Engineers Comments Regarding Surface Water Drainage

Application Reference:	AL/52/26/PL	Reviewer Reference:	ADC/EXT5/AF
Planning Officer:	Hebe Smith	Date of Review:	17/08/2026
Site Name:	The Grange Westergate Street Westergate PO20 3SQ		
Application Description:	Removal of mobile home and replacement with 1 No. self-build dwelling and associated works. This application is in CIL Zone 1 (Zero Rated).		
Assessment Number:	1

DRAWING TITLE
PROPOSED DRAINAGE STRATEGY

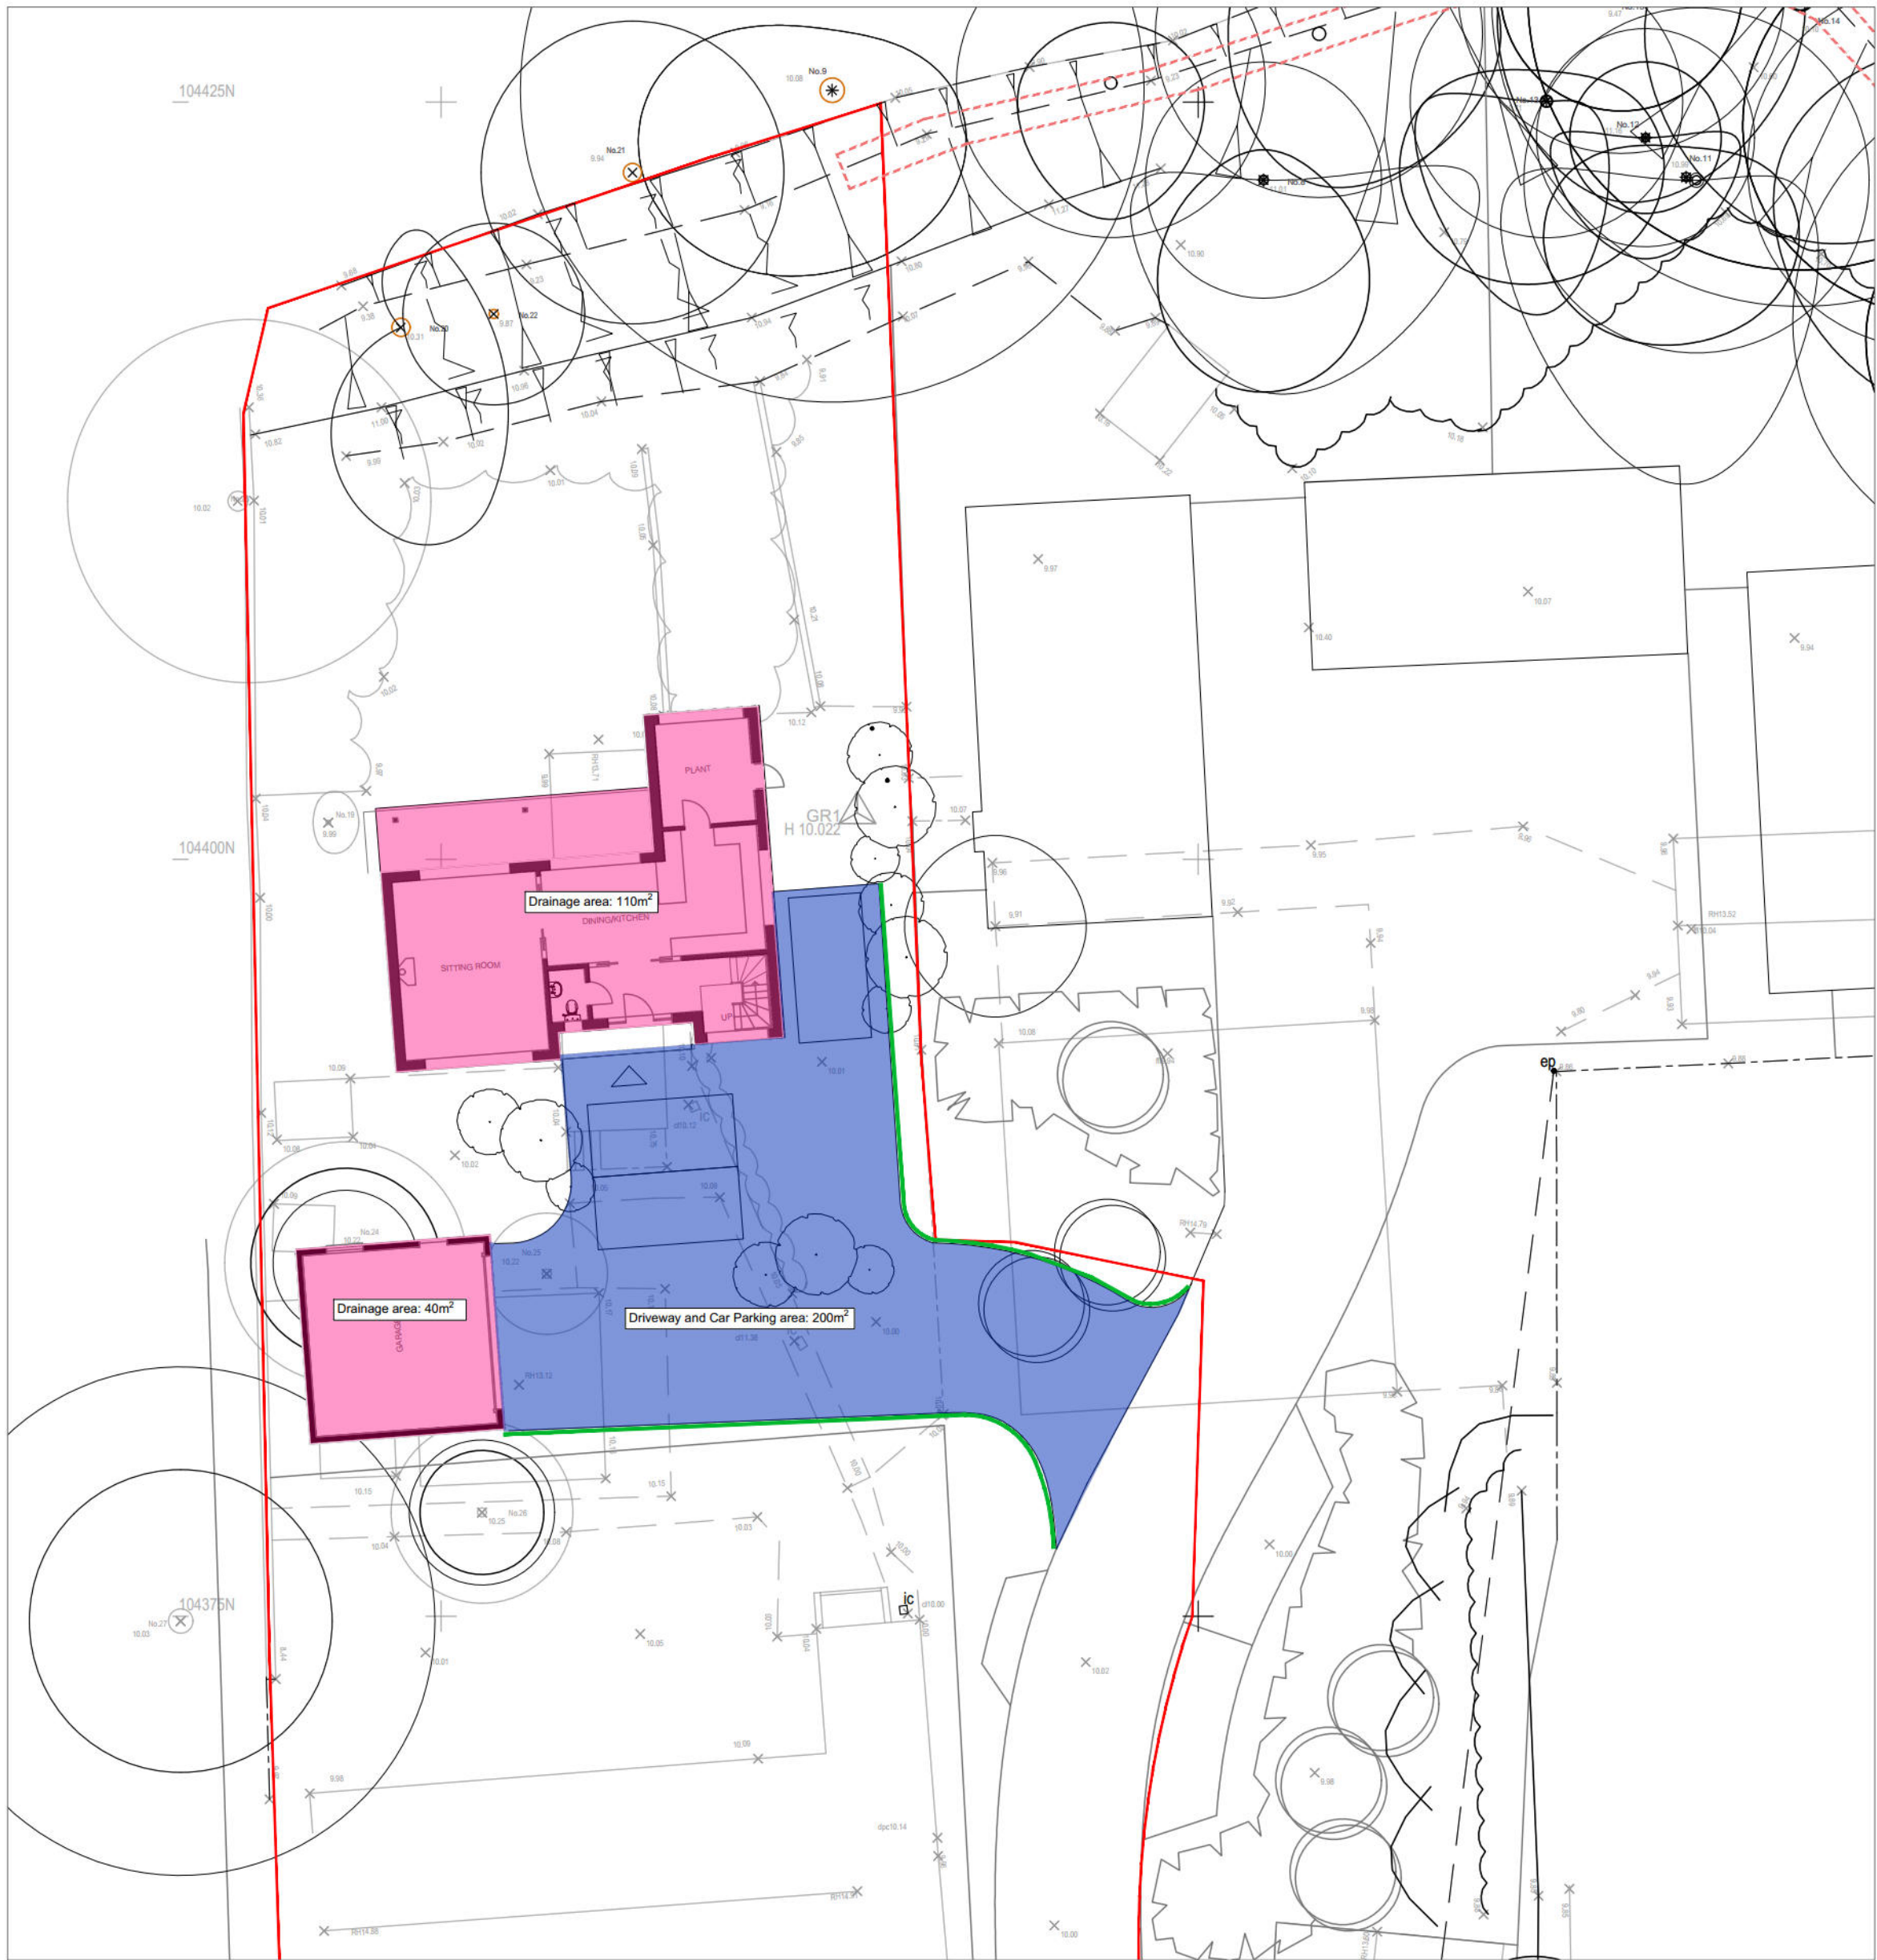
- 2.1. The drainage layout plan is missing from the drainage report appendices and measures to control interception runoff are not clear. Lined permeable paving is acceptable for the self-drained area. There may be a need for landscaping features such as swale, planters, rain gardens or similar to accommodate the roof area and any hard pavings which are not permeable.

- 3.1. The drainage areas and drainage layout plans are missing from the drainage report appendices. We are unable to assess the drainage proposals or audit the calculations.

- 3.4. The design peak flow rate of 0.1 litre per second is at the lowest end of what we would consider to be practicable and requires enhanced blockage protection. The flow control device is an orifice size of 8mm, which will be susceptible to blockage and require blockage protection. The flow control chamber type is noted to include a blockage grill, which should be checked is suitable for this small orifice size. In addition to measures within the chamber, the design should reduce risk of detritus reaching the flow control chamber by filtering all runoff through the permeable paving or similar measure. No rain water pipe, gully or other inlet should be connected to the chamber without filtering the runoff. This may or may not already be the case and we await submission of the drainage layout plan.

- 4.1. The drainage layout plan is missing from the drainage report appendices and we are unable to assess water quality mitigation. Permeable pavement is a suitable treatment stage for a lightly trafficked driveway and residential parking.

- 5.1. The drainage layout plan is missing from the drainage report appendices and we are unable to assess amenity as an aspect of multifunctional sustainable drainage design.
- 5.2. The permeable paving and rainwater harvesting could be augmented with small scale SuDS planters / pods or other landscaping features as measures proportionate to the nature and scale of the development.

EXCEEDANCE FLOW ROUTES (scale 1:200)

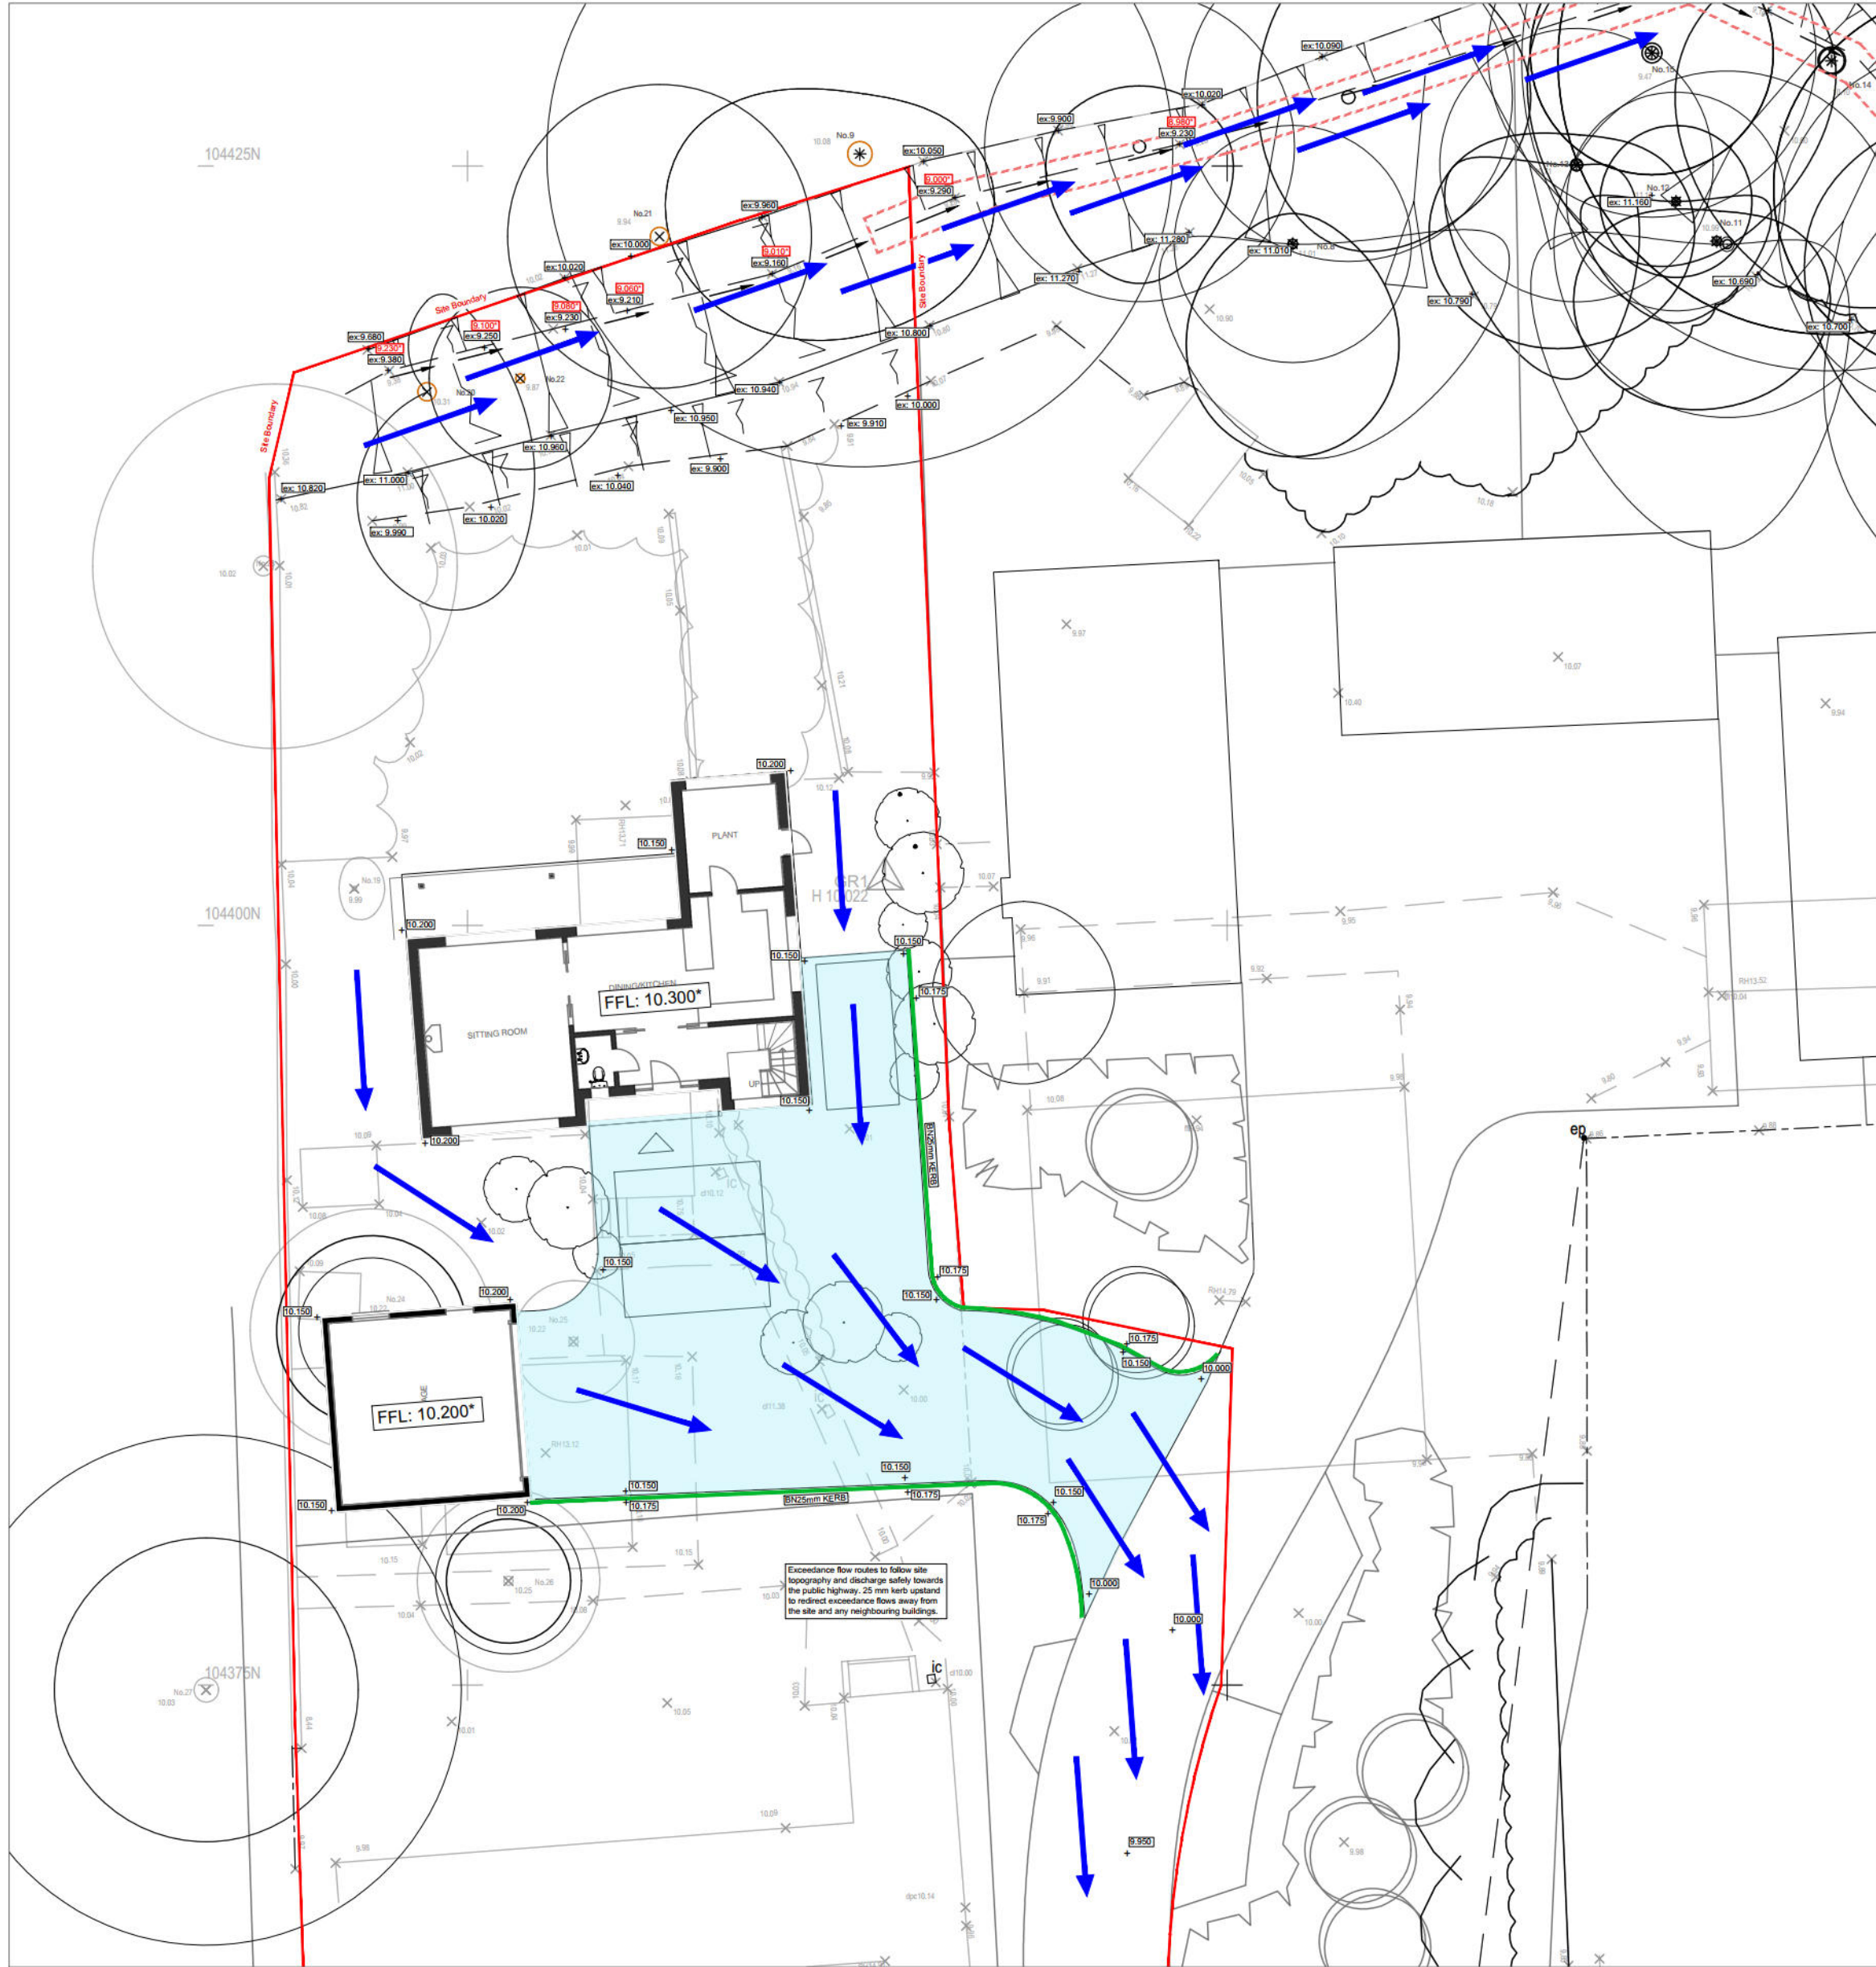
- 3.2. The greenfield runoff calculations are not legible in the appendices of the drainage report.
- 3.3. A suitable downstream surcharge should be incorporated to reflect the anticipated top water level in the ditch during the design storm.

- 3.5. The design to manage extreme rainfall is not currently demonstrated to be in accordance with the requirements of NSfS Standard 3. Therefore, we **object** to the application.
